Planning Application Ref: BR/316/18/PL

Location: Abbots Lawn, Sylvan Way, Bognor Regis, PO21 2RS

Description of works: Single storey extension to west elevation

block plan

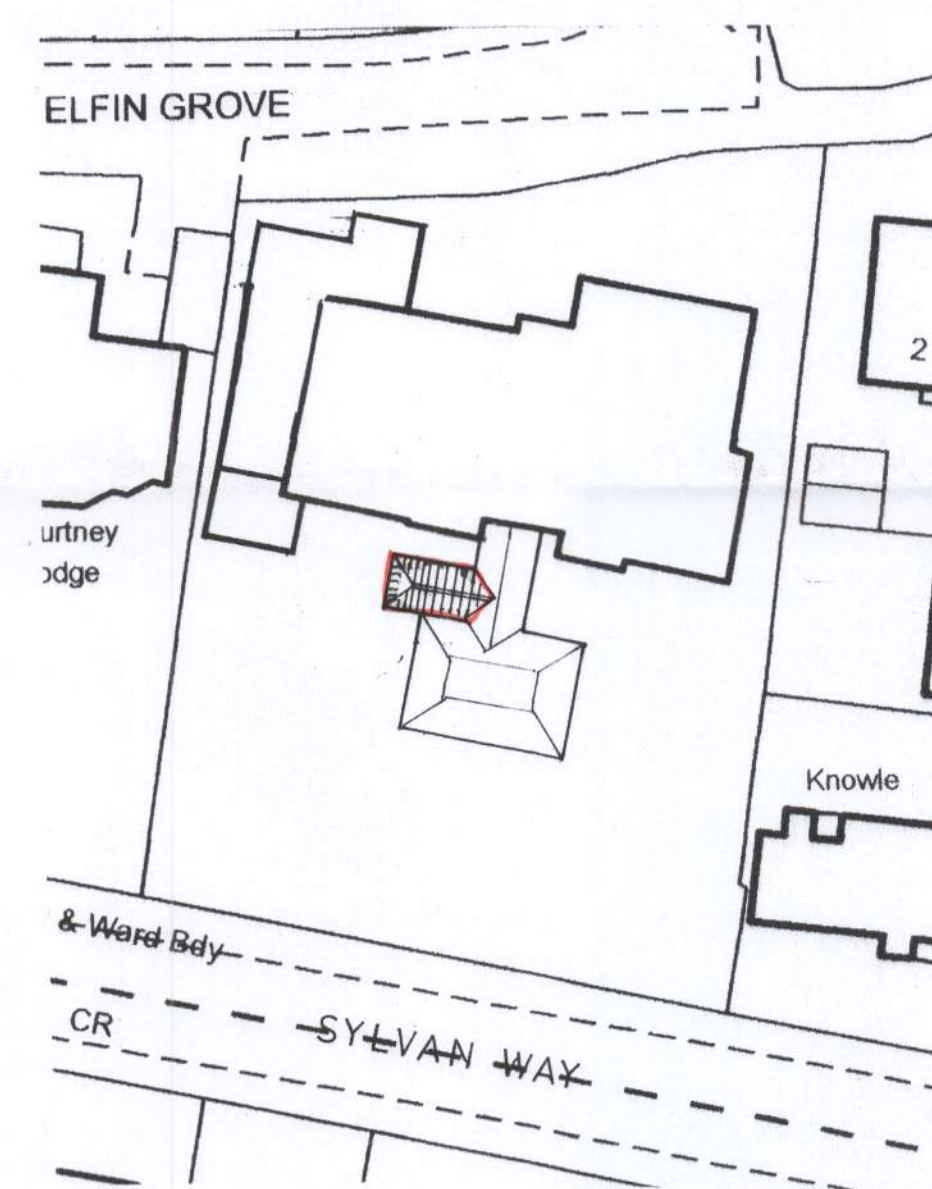
- There are significant trees both on and off this site which could be adversely affected by the proposals. There is no supporting arboricultural information submitted with the application - a requirement of BS5837:2012. As such, were this development proposal to now proceed, we will not have sufficient information to guarantee such trees would be adequately respected and protected.

- Although the property benefits from a good density of tree stock, notably along the south and west boundaries, some of these will inevitably have to be sacrificed during the provision of adequate parking facility. In any event, an engineering solution such as 'No-dig' construction may be necessary to ensure those retained trees can survive without detriment to their ongoing health and vitality, although we cannot determine this until the applicant's appointed arboriculturalist has provided a detailed report and set of plans, which demonstrate the viability of and make recommendations for - that element of the proposal.

- Those trees of significant value upon the site are confined to the west and southern boundaries, two of which (a mature lime and semi-mature yew) are of sufficient value to justify the making of a Tree Preservation Order. The other trees on and immediately adjacent the site may be considered important for their screening value although due to their age, condition and management history ought not to be a complicating factor in development of the site.

- The applicants will need to employ the services of an Arboricultural Consultant to carry out a tree survey exercise and then prepare an Arboricultural Implications Assessment (AIA) which must be inclusive of; a 'Tree Survey Schedule', a 'Root Protection Area (RPA) Schedule' and a 'Tree Constraints Plan' – with the trees accurately plotted on same.

- In the event that a RPA of any tree which is proposed for retention overlaps the development then BS5837:2012 requires that the Detailed Planning Application is accompanied by an Arboricultural Method Statement (AMS) and also most importantly a Tree Protection Plan – to both describe and illustrate the mitigation measures which are to be employed to ensure that the trees survive without detriment to their vigour and vitality and are given adequate protection both above and below ground.

- I recommend the making of a Tree Preservation Order to cover one lime and one yew tree. Please follow this link to TEMPO forms and site plan to assist you in making this order - [N:_Everyone\Folders\Mark Warwick\Bognor Regis\Sylvan Way.Abbots Lawn](#)
